## Design Review Panel No. 1 Advice

<b>Meeting Subject:</b>	600-660 Elizabeth Street, Redfern  Design Review Panel Meeting No. 1		
<b>Location:</b>	In person: Ethos Urban – 180 George Street, Sydney  Virtual: Teams		
<b>Date:</b>	21 November 2023	<b>Time:</b>	9:00am – 12:30pm

This letter summarises the Design Review Panel's (DRP) commentary on the material presented by Hayball and Aspect at the first DRP session held on 21 November 2023. The focus of the meeting was on the overall design concept, the public domain approach, and key matters associated with the social and affordable housing buildings in the 600-660 Elizabeth Street, Redfern project.

Status:  
STATE SIGNIFICANT  
DEVELOPMENT APPLICATION  
Drawing Title:  
BASEMENT PLAN

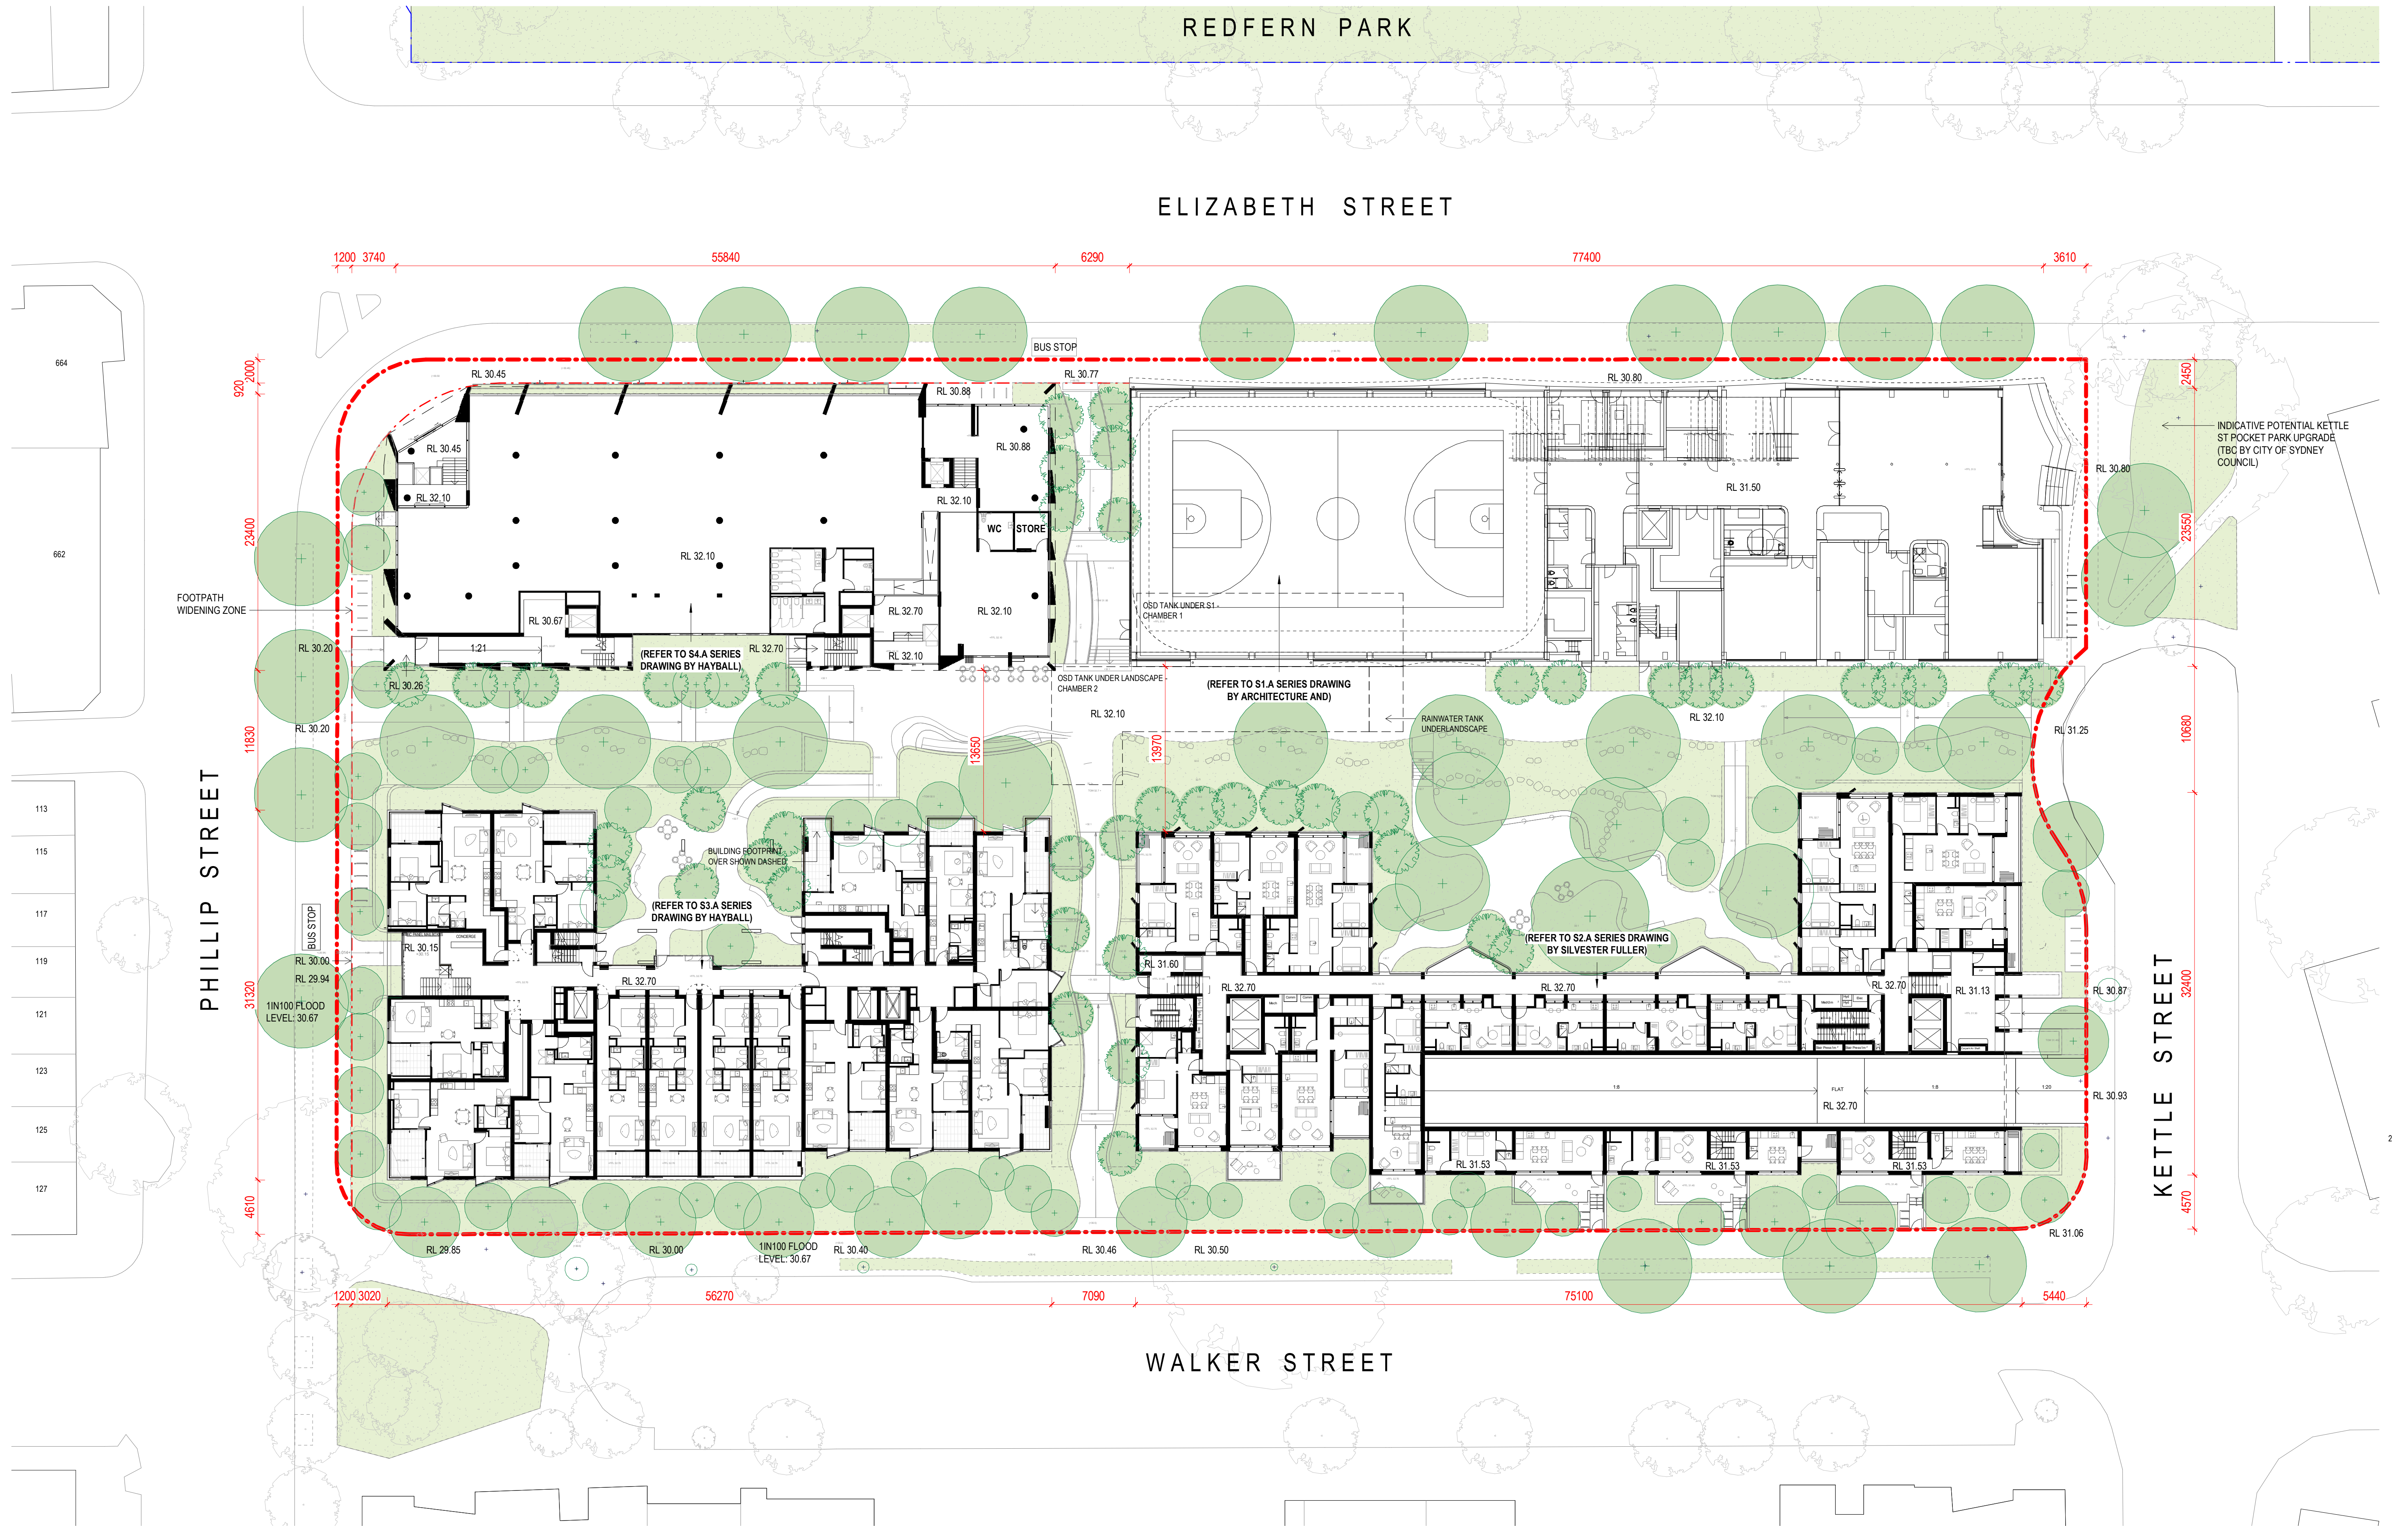
Waste and Servicing	<ul style="list-style-type: none"> <li>• The current waste strategy and collection point from Walker Street was not supported based on the information provided. The design team need to provide further review and consideration in the context of the overall loading and servicing strategy for the project, and in the context of the site-wide principles</li> <li>• The Panel was concerned with the co-location of the waste collection point and the building entry, and how this may be treated. Further consideration of how this solution could positively contribute to the streetscape and resolve adjacency issues is required.</li> <li>• Coordination with a waste consultant and Sydney City Council is required to establish the best waste strategy, particularly considering the different residential tenures and other uses proposed. The collection of various waste streams from the different uses should be understood and accommodated.</li> <li>• Further detailed analysis is recommended to establish the strategy for waste collection points for each building, aligning with the location of cores. For instance, the Panel acknowledged the need for the southern core of the Affordable Housing building to be amended to provide access to the basement.</li> <li>• The coordination and transport of waste across the site requires further analysis and resolution. For instance, the Panel did not support the movement of waste through the Social Housing building foyer.</li> <li>• A comprehensive servicing and loading strategy is recommended, identifying how each building will be serviced, including how activities such as moving-in/moving-out will occur.</li> </ul>

Focus Areas	Panel Commentary
Waste and Servicing	<ul style="list-style-type: none"> <li>Prior to the meeting, the concept design's approach to waste was referred to the City of Sydney waste and traffic teams who found the location of the loading dock on Walker Street unacceptable for the following reasons: <ul style="list-style-type: none"> <li>Large vehicles reversing over the pedestrian footpath present a safety risk, particularly since the loading dock is adjacent to the residential lobby entrance.</li> <li>The plans submitted show the waste truck protruding over the landscape strip, indicating it cannot fit wholly within the loading dock.</li> <li>The 3-point turn arrangement is considered to conflict with the existing parking on Walker Street and if there was a truck within the loading space, no other truck could undertake a 3-point turn.</li> <li>The mezzanine configuration is odd and should be avoided since it makes moving goods throughout the basement difficult.</li> </ul> </li> <li>Council's waste and traffic teams recommended that loading, deliveries and servicing be provided within the basement and that the collection be in accordance with the relevant standards.</li> <li>The Panel requested the design team explore alternative waste management options and these be discussed with technical staff at Council. This may include: <ul style="list-style-type: none"> <li>Basement waste collection – noting that this would likely result in a reduction in yield for the S2 building. Options to redistribute the lost yield should be investigated, such as including some built form within the proposed Phillip Street pocket park.</li> <li>At-grade waste collection within the confines of the site – provided safety concerns and manoeuvring can be accommodated and a high-quality ground plane achieved. This option appears challenging.</li> </ul> </li> </ul>

Building S3	<ul style="list-style-type: none"> <li>• The Panel strongly supported the relocation of waste collection into the basement and the removal of the at-grade loading dock.</li> <li>• The change in siting and design results in a better street frontage to Phillip Street, providing a strong street address which was considered a positive move.</li> <li>• It was recommended that opportunities for a sense of ownership and personalisation within the open corridors be explored, possibly taking cues from Building S2.</li> <li>• In relation to the last three apartments on the ground level, it was considered a stretch to get from the terrace, down stairs to the public footpath. Consider whether a better outcome may be achieved without a staircase and potential additional tree planting in their place.</li> <li>• The Panel requested: <ul style="list-style-type: none"> <li>- further design refinement is undertaken for the Phillip Street frontage to ensure it does not read as a series of walls.</li> <li>- further design refinement is undertaken in relation to the internal layout of the narrow apartments to achieve cross ventilation other than the high-level bedroom window, such as a fly screen security door.</li> <li>- further consideration be given to increasing the unencumbered deep soil to the Walker Street footpath from some of the ground level apartments by removing terrace access to footpaths from some terraces.</li> </ul> </li> </ul>
